**CITY OF PORTLAND
PORTLAND FIRE DEPARTMENT**

Inspection Violations

Owner/Manager 40WATERVILLE LLC		Inspector Doug Morin	Inspection Date 4/15/2015
Location 40 WATERVILLE ST	CBL 017 E014001	Status Violations Exist	Inspection Type Fire Prevention-Housing Inspecti

SHEET TITLE FIRST FLOOR PLAN

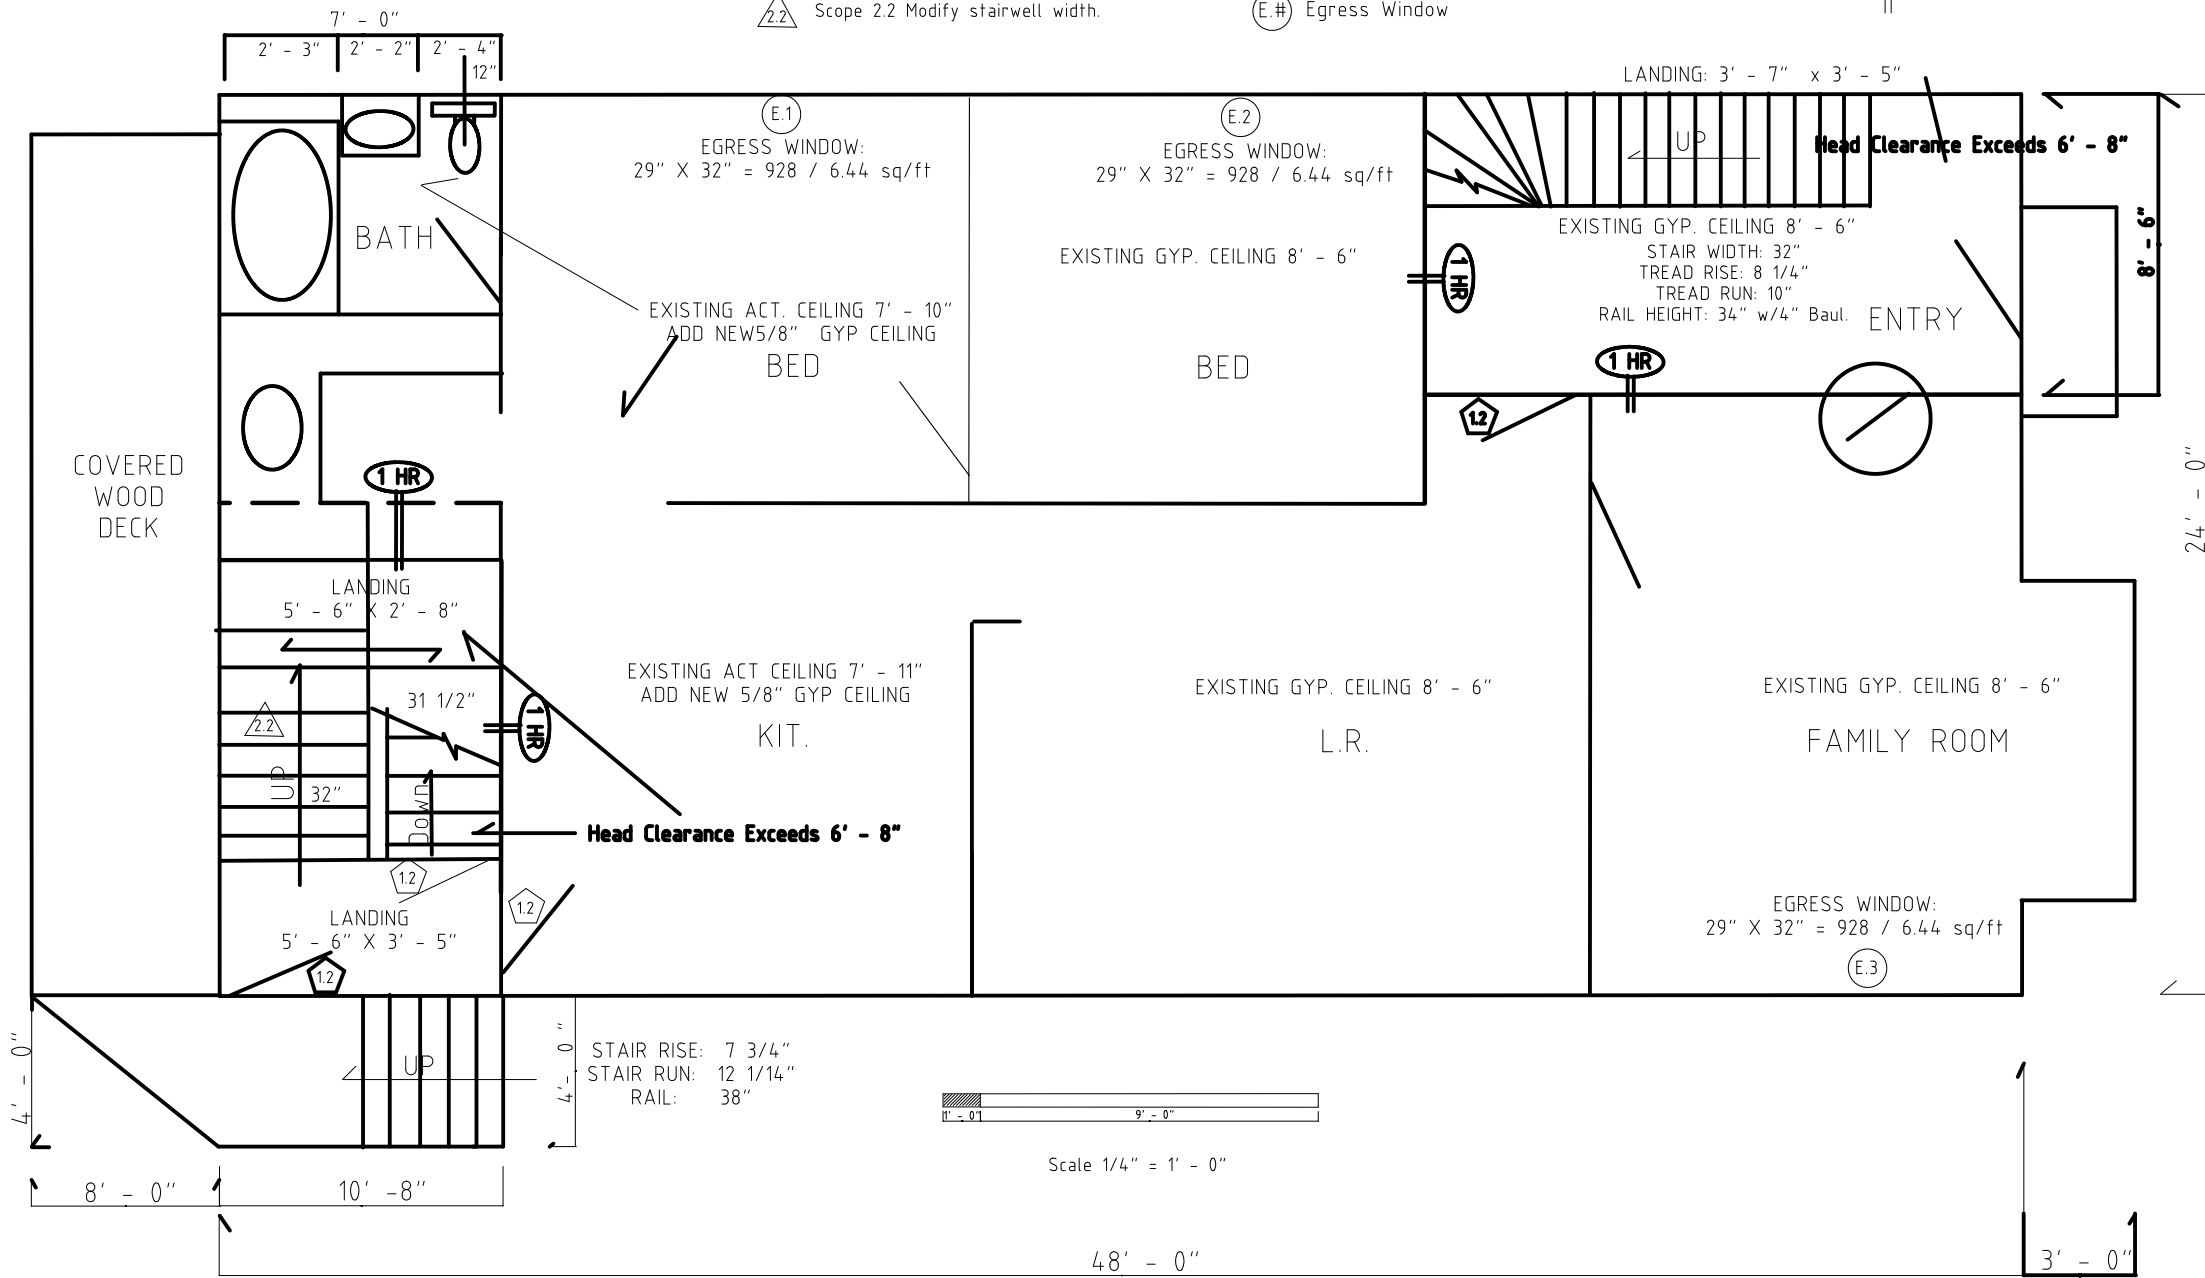
Violation: NFPA 101- 31.3.3.2 INTERIOR FINISH; INTERIOR WALL AND CEILING FINISH MATERIALS COMPLYING WITH 10.2 SHALL BE PERMITTED AS FOLLOWS:

Notes: HALLWAY FINISH SHOULD BE DRYWALL

SHEET TITLE  
**BASEMENT  
ELECTRICAL  
PLAN  
A.1.4**

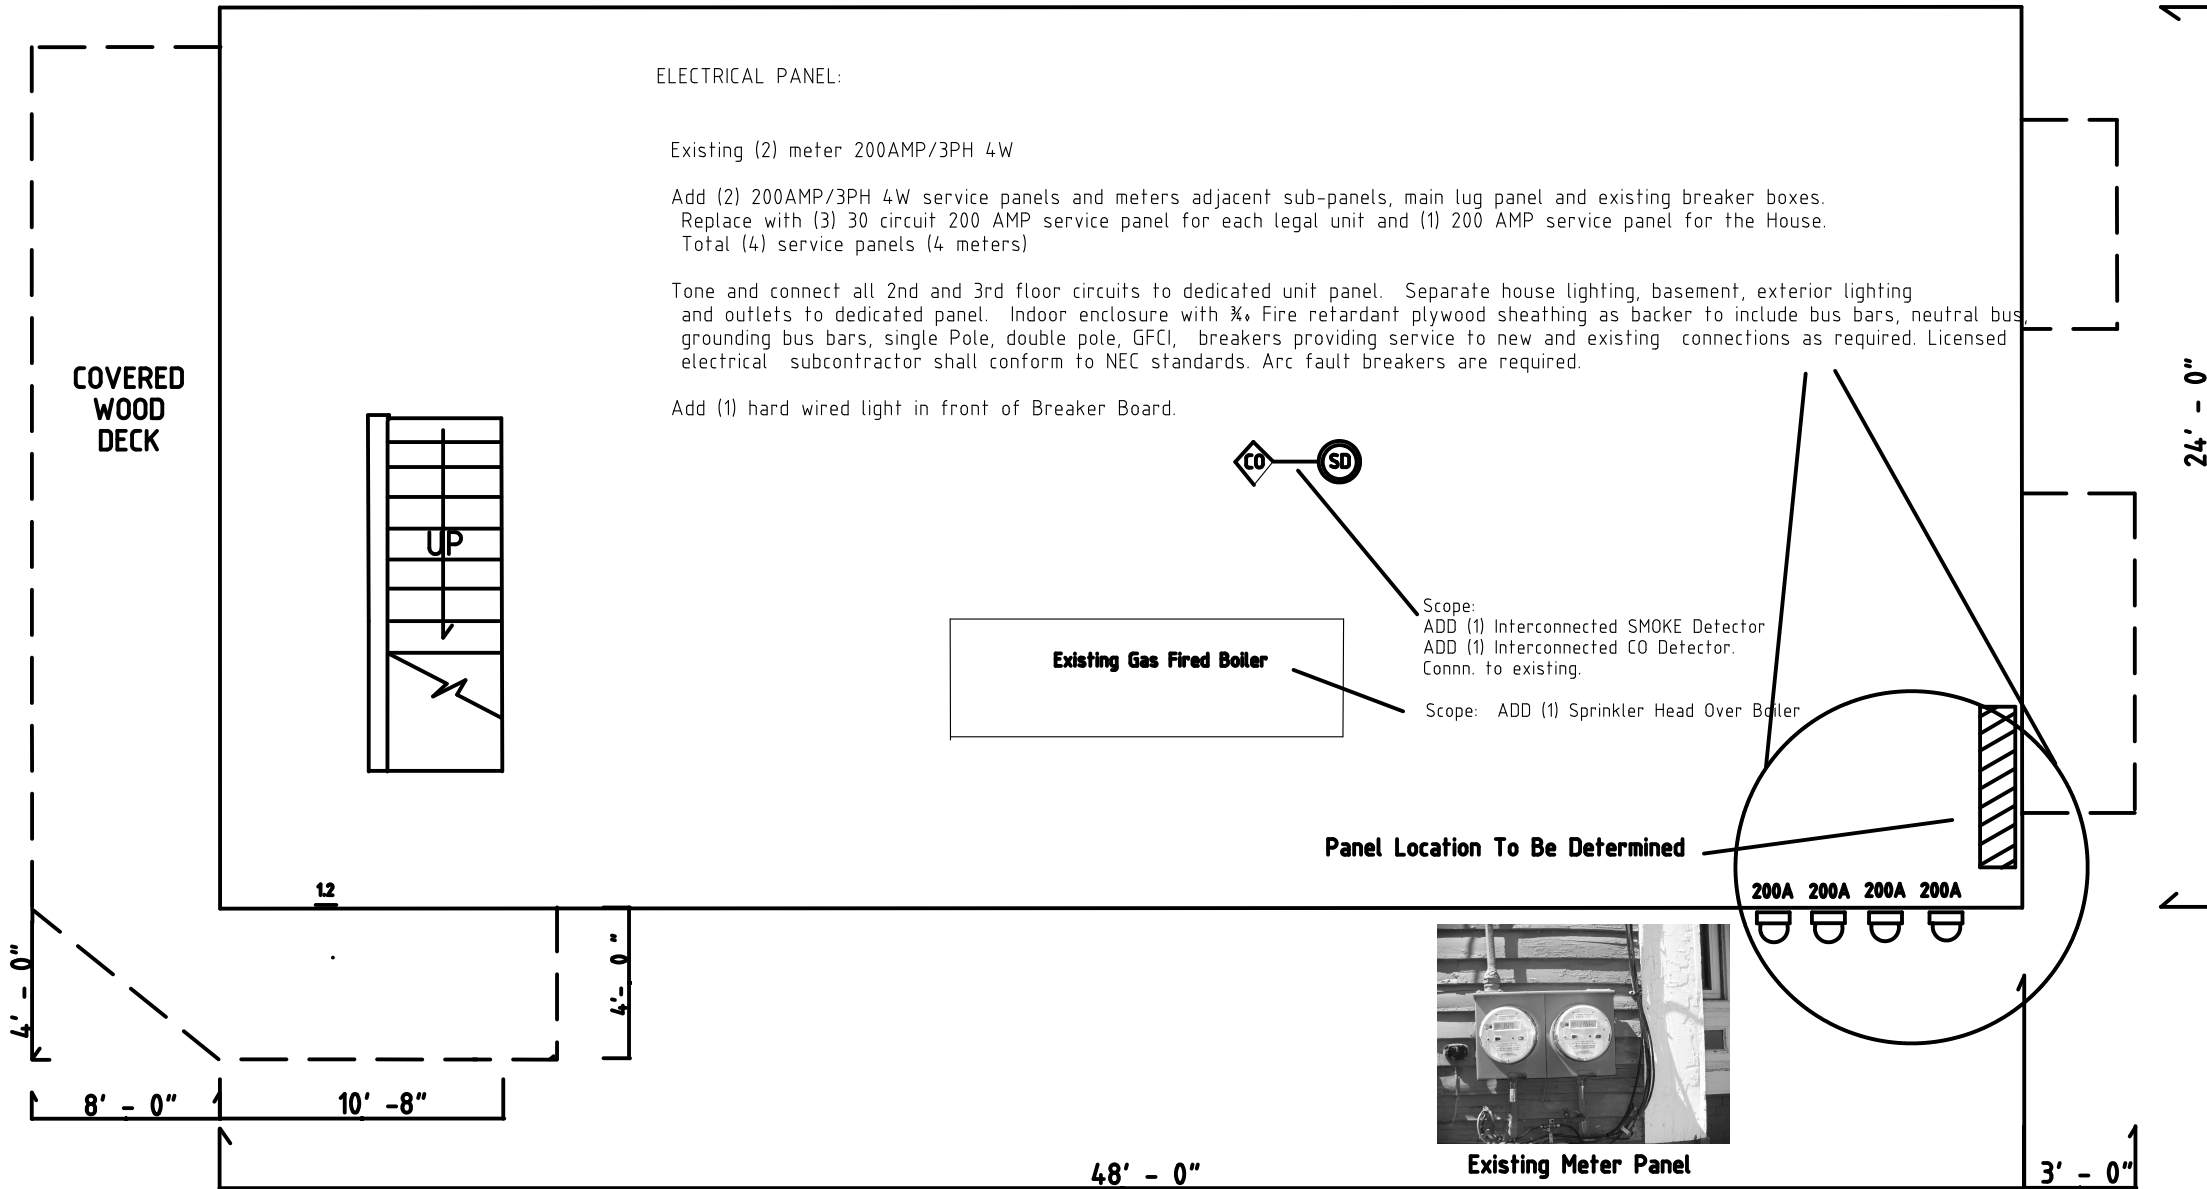
Notes: SMOKE AND CO DETECTION IS REQUIRED IN BASEMENT AND HALLWAYS.
SMOKES AND CO DETECTORS THAT ARE >10 YEARS OLD SHOULD BE REPLACED.

Violation: NFPA 101- 31.3.2.1.1 BOILER PROTECTION REQUIRED; THE AREAS DESCRIBED IN TABLE 31.3.2.1.1 SHALL BE PROTECTED AS INDICATED:
BOILER AND FUEL-FIRED HEATER ROOMS SERVING MORE THAN A SINGLE DWELLING UNIT (MINIMUM SEPARATION/PROTECTION IS 1 HOUR OR SPRINKLERS)

Notes: SPRINKLER HEAD REQUIRED

SHEET TITLE DECK DETAIL

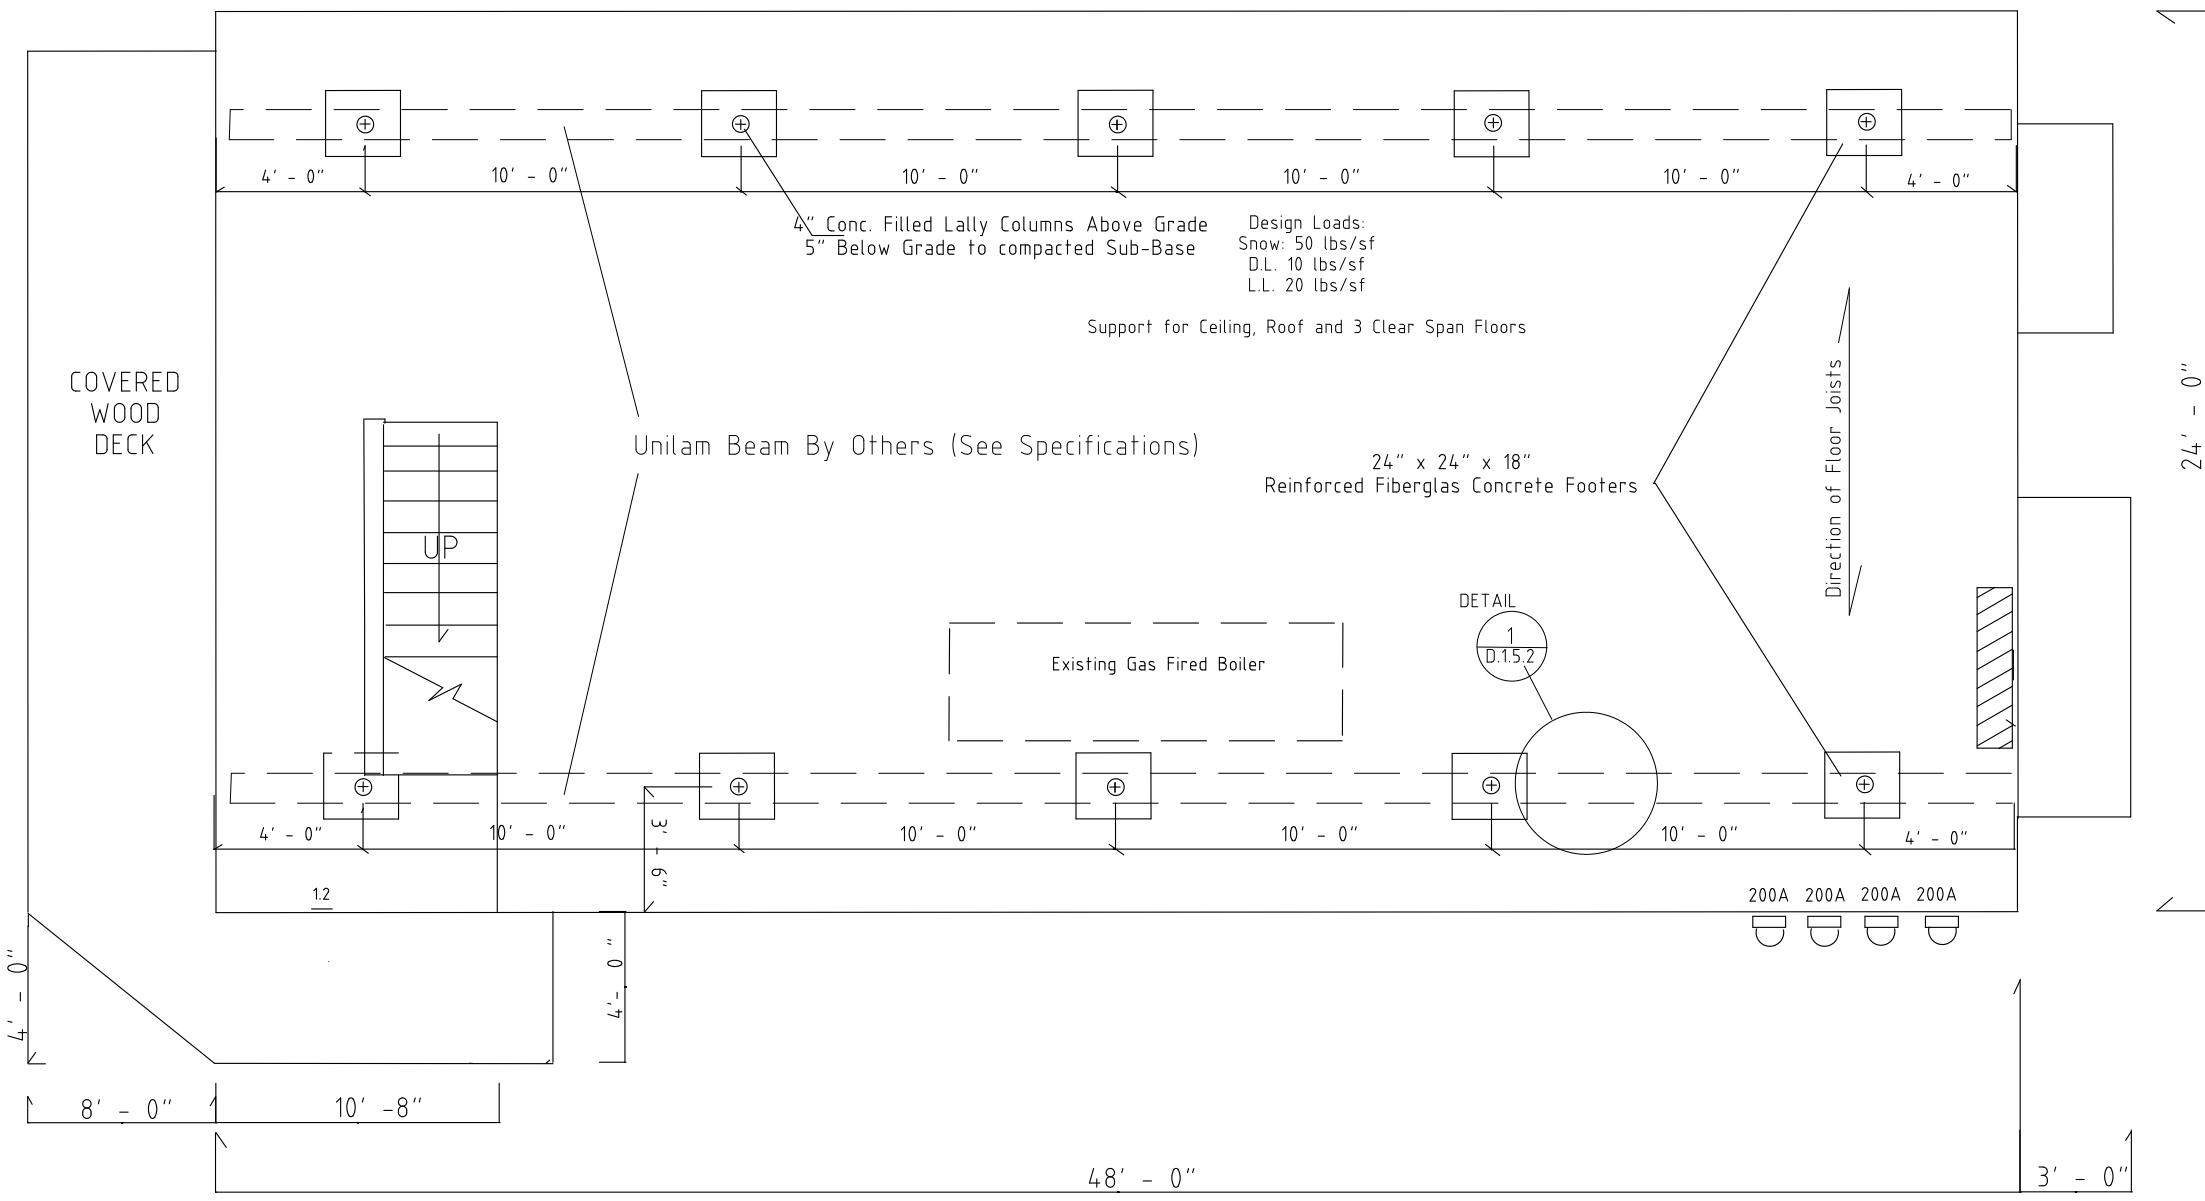
Comments: Third floor is an illegal unit. Rear Decks appear to have been built without a permit, need structural engineer approval. It is unknown what the ledger to band joist is, but it is specifically not attached per code specs, ie; staggered 1/2 inch lag screws or listed product. There is also no lateral load connection in the prescribed two location minimum. Basement floor joist are supported at foundation wall with pressure treated lumber and adjustable columns, structural engineer will need to inspect and approve repairs. Several holes and penetrations need sealing above suspended ceiling for continuity (1st floor). Life safety needs complete updating from fire doors to updated smoke detectors as well as carbon monoxide detectors. Sprinkler needed in basement over the fuel fired furnace. To legalize the third unit the apartment will need it's own meter and a house meter added as well for all common area power.
